From: Simon Davis
Sent: 16 November 2018 12:49
To: Planning JPA; 'James Potter'
Subject: FW: FP/171/18/PL

From: Mark Warwick
Sent: 16 November 2018 12:17
To: Simon Davis
Subject: FP/171/18/PL

I refer to my previous comments in respect of this development proposal (19th September and 6th November) and for the record sustain my OBJECTION in the absence of a satisfactory revision to the site layout/access.

scheme: Land West of Stanhorn Grove
Felpham
client: Worthing Homes
drawing: Tree Protection Plan
date: October 2018
scale: 1:200@A1
dwg no: PRI21588-03
drawn: RA checked: MW

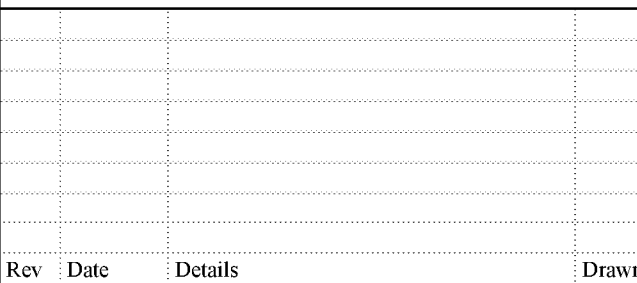
Prior to applying the aforementioned conditions, it will be necessary for the applicant to submit for our approval, the precise areas where ground protection measures and ‘No-dig’ solutions are to be employed and provide a detailed specification for each – then illustrate those areas clearly on the Tree Protection Plan.
